Recommendation Report for Planning Permission for Works or Extension to a Dwelling

REF NO: BN/39/25/HH

LOCATION: Greenings
Eastergate Lane
Eastergate
PO20 3SJ

PROPOSAL: Removal of previous extensions and construction of a two storey rear extension, single storey side extension, replacement front porch, new ground floor front bay windows, external cladding and re-rendering, and realignment of front entrance drive.

PROPOSED SITE LAYOUT PLAN

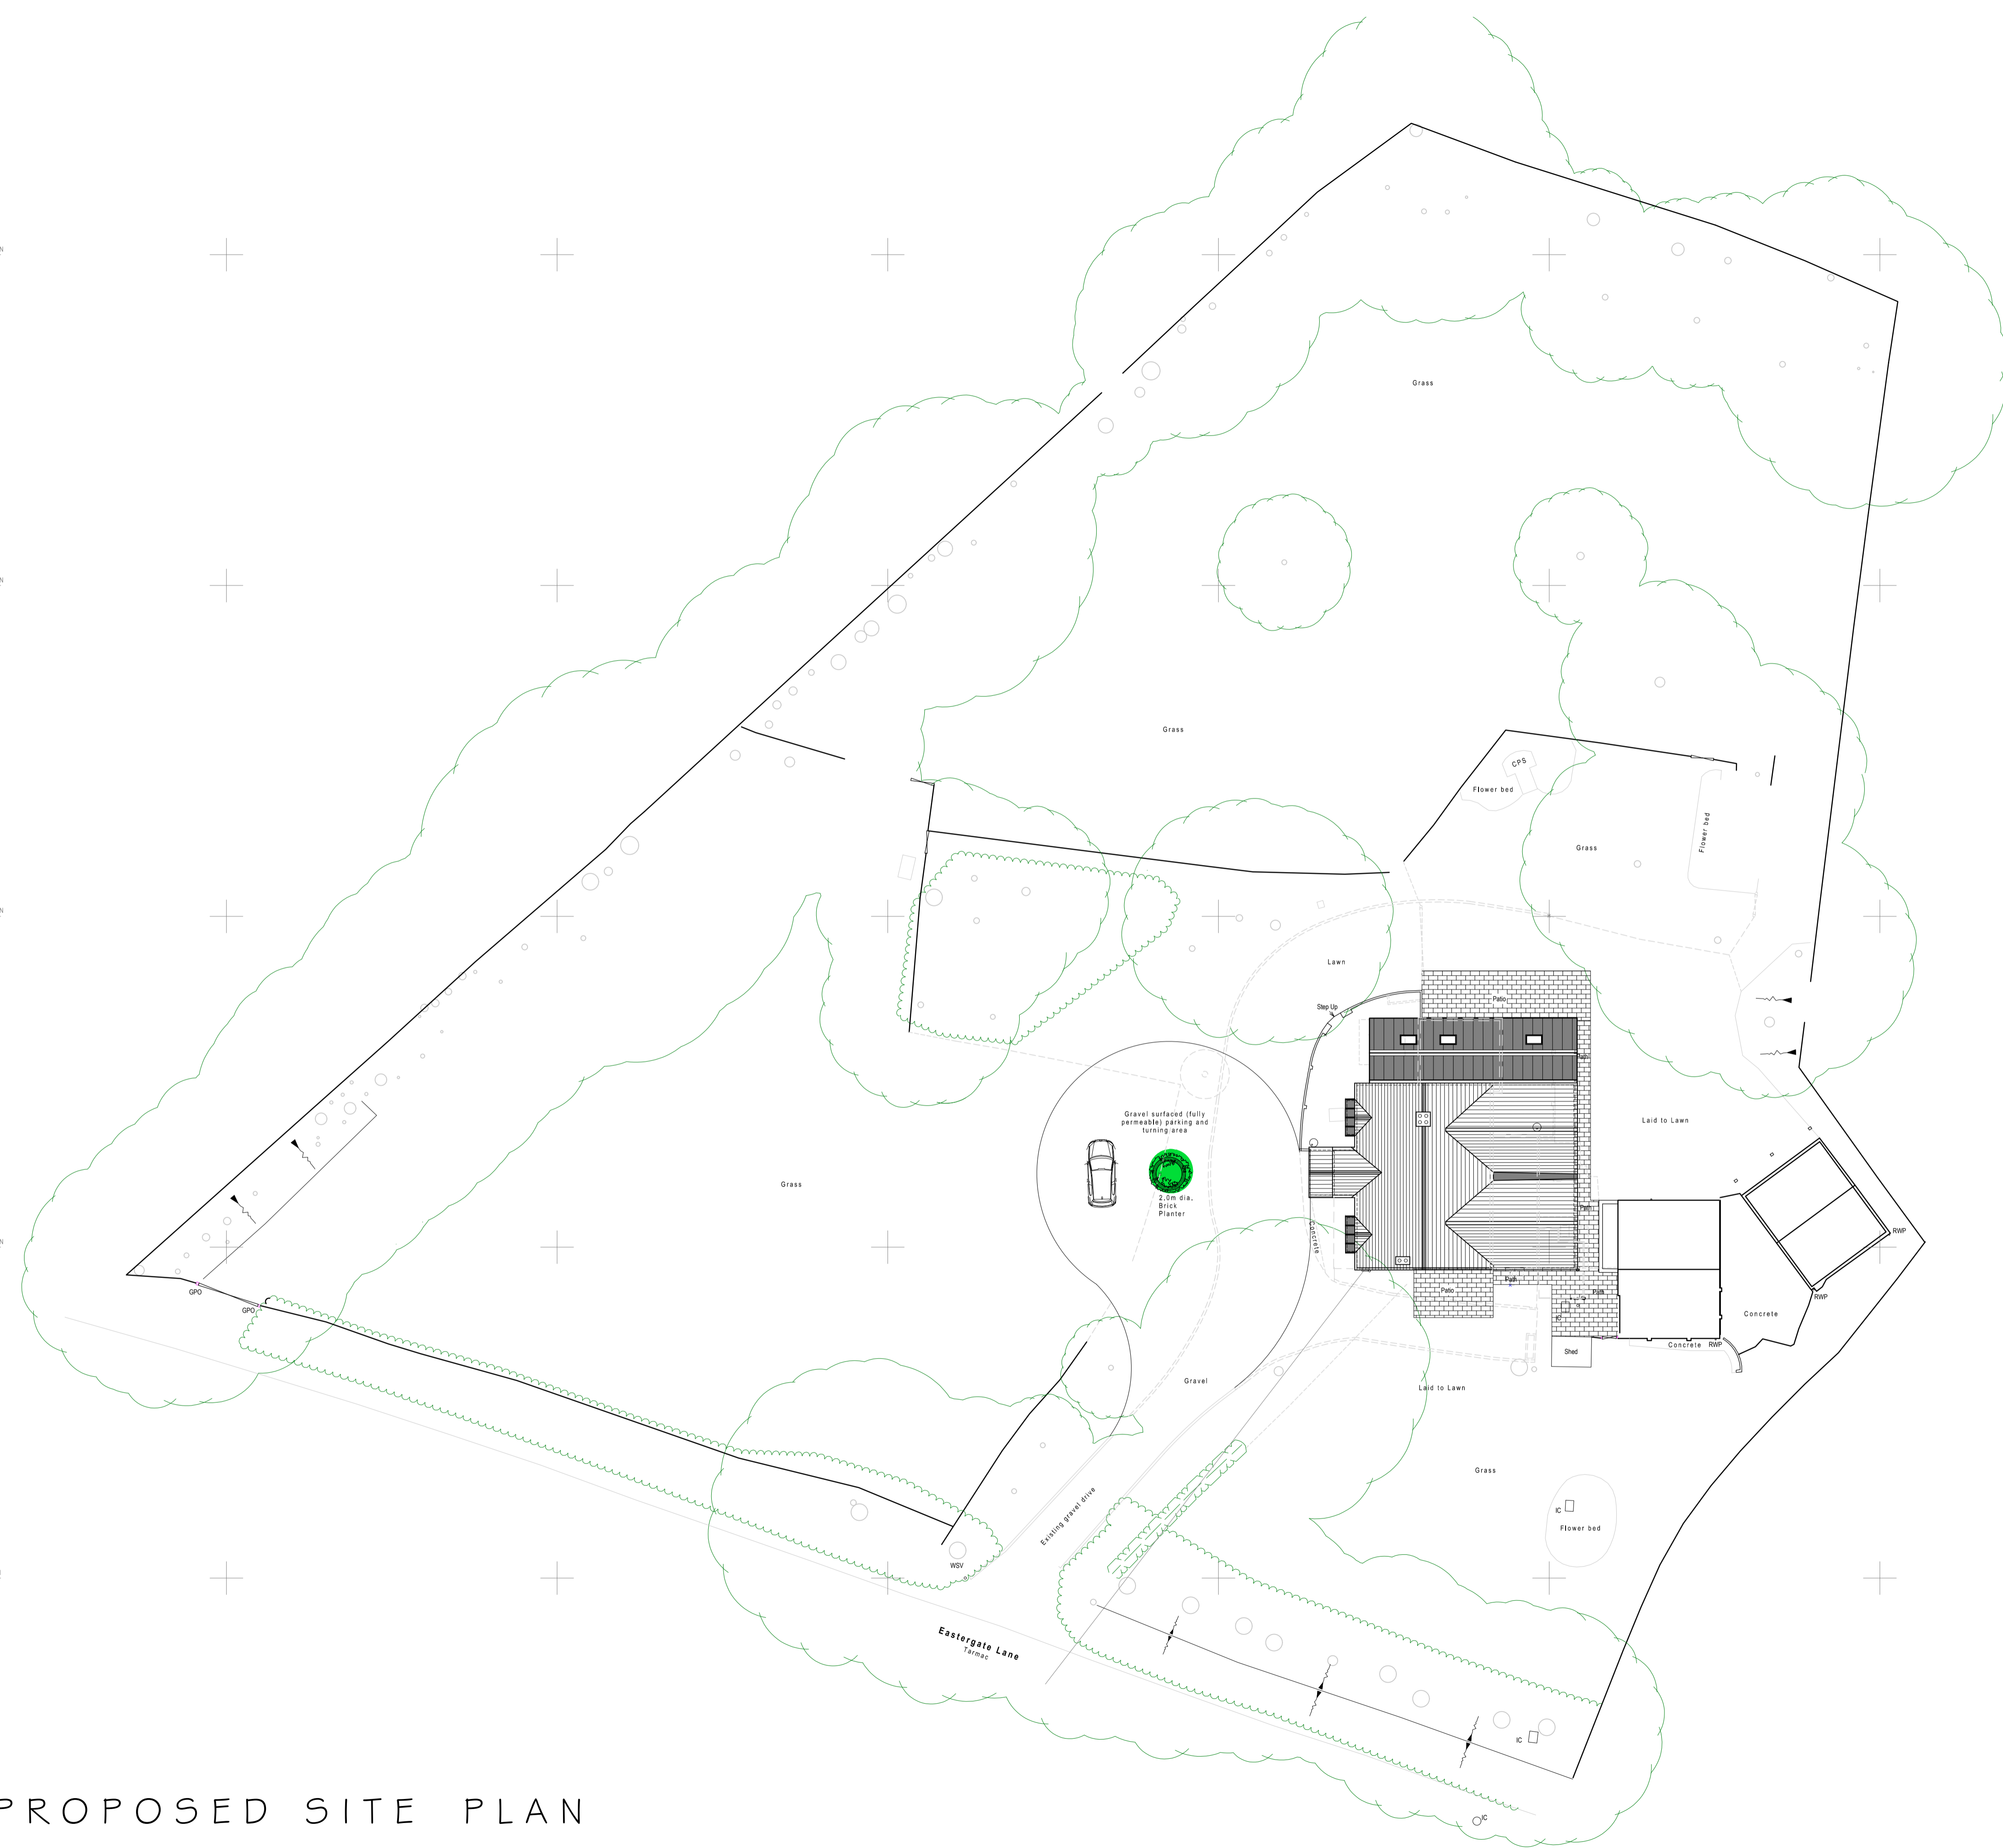
The realignment of the driveway would have a minimal impact on the character and visual amenity of the property or wider area.

REV	DESCRIPTION	DATE
PROJECT		
'GREENINGS', EASTERGATE LANE, EASTERGATE, CHICHESTER WEST SUSSEX PO20 3SJ		
DRAWING TITLE		
PLANS SHOWING ROOF DRAINAGE AREAS		
SCALE	DRAWN BY	DATE
1:200 @A3	PLB	APR 25
DWG NO	1401/08	REV. -

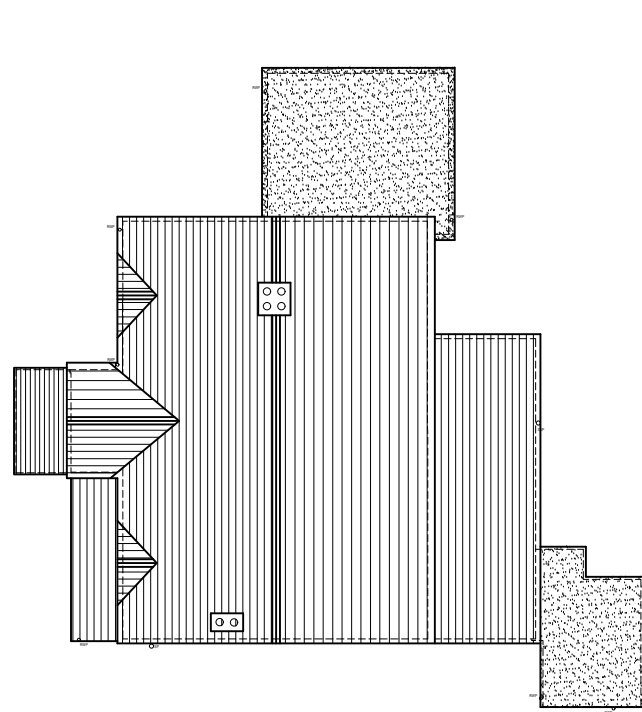
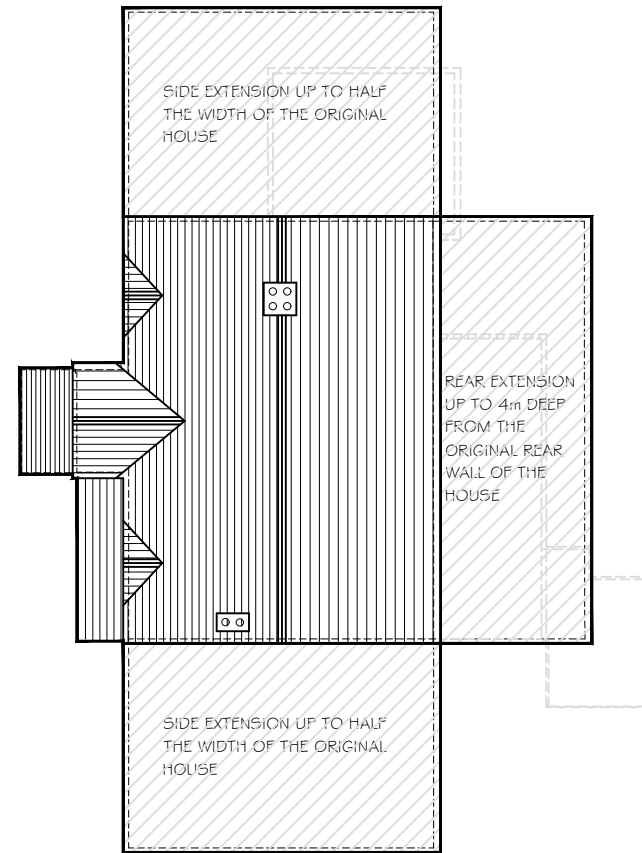
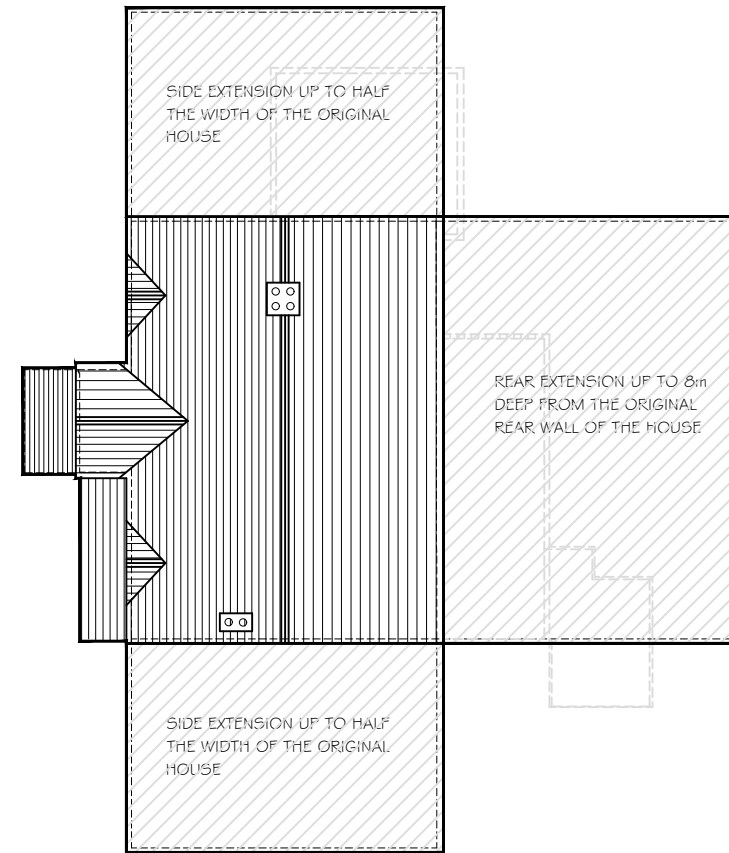
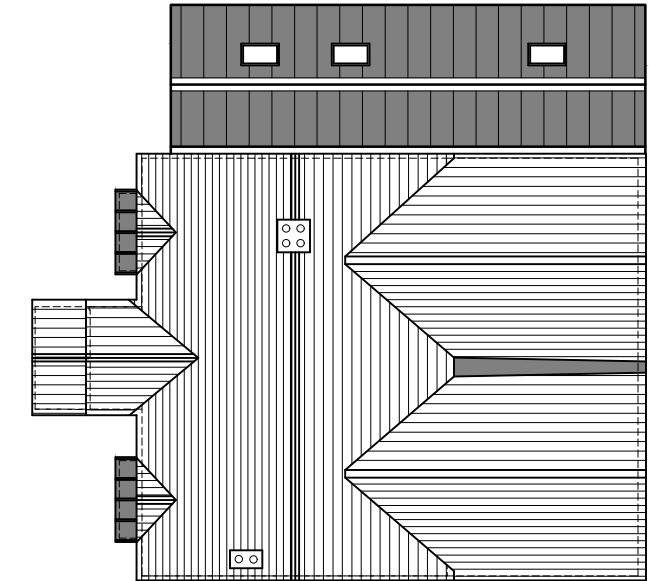
increase in floor area and no information has been submitted regarding the proposed method of draining the site. No response has been received from ADC's drainage engineers on this application. A plan has been submitted in support of the proposal, demonstrating the level of development which could be possible under permitted development. It is noted that the proposed area of the proposed development is smaller than that shown on the plan, however, this in itself does not make the proposal acceptable in terms of drainage.

The proposed additional floor area would be located to the side and rear of the site, and extensions to these elevations could be constructed under permitted development. Although the current proposal is not permitted development, this is largely due to the fact that the rear extension is two storey, and the side extension connects to the rear extension. The construction of a rear extension with two storeys, rather than one does not increase the area to be drained which is proposed. Given that a small gap could be introduced between the two extensions, without meaningfully reducing the area to be drained, the proposal is considered sufficiently similar to one which could be undertaken through permitted development.

Given that the impact of the proposals on drainage is similar to that which could be achieved via permitted development, a refusal on drainage grounds would not be reasonable in this instance. The proposals would not increase flood risk elsewhere, in accordance with policies W DM1 and W DM3 of the Local Plan.
